State of Washington  
DEPARTMENT OF FISH AND WILDLIFE

August 30, 2024

SUBJECT: WDFW COMMENTS ON RZ-24-00002 Spring Tree Ranch Rezone

REVISED SPRINGTREE RANCH MASTER PLAN - SITE PLAN

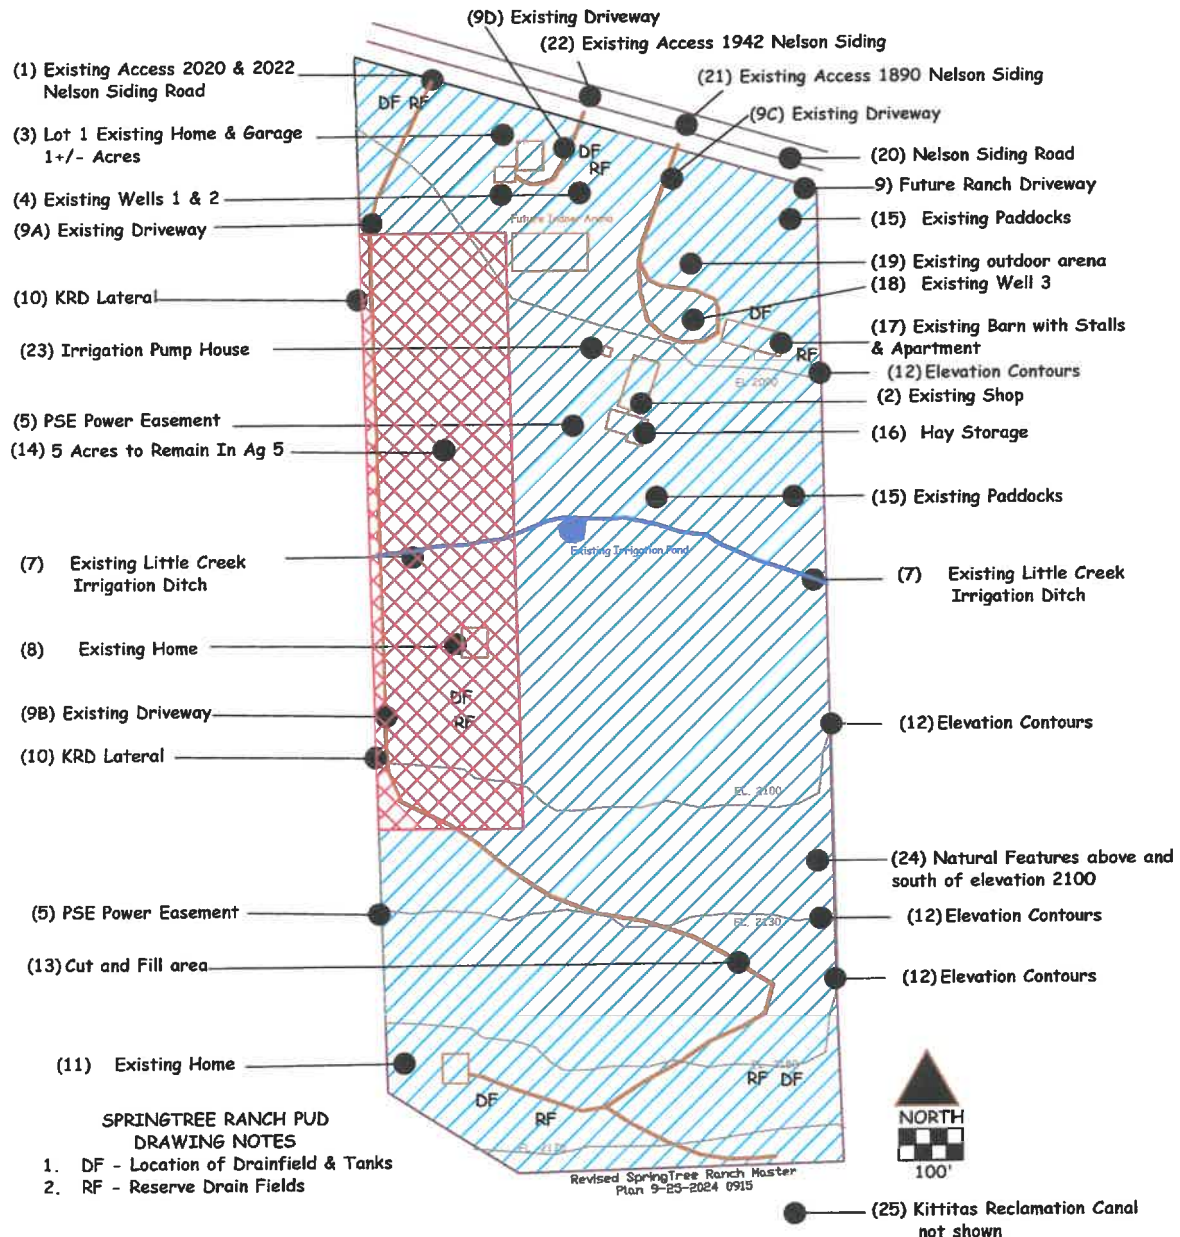
While WDFW appreciates that a critical areas report was conducted for parcels 376334 and 396334, it appears that the report did not cover parcel 386334 nor did it cover all areas of parcel 396334. The report appeared to focus on the northern area of the application, but the master site plan shows future development in areas outside of the area covered under the critical areas report. Further, the critical areas report does not discuss whether the shrubsteppe habitat mapped within WDFW Priority Habitats and Species (PHS) maps exists or not. WDFW requests that prior to approval, a revised critical areas report be updated to include coverage of the entire that is under consideration for development by this proposal, including report on both potential wetlands and shrubsteppe. WDFW would appreciate the opportunity to review the findings of the updated critical areas report.
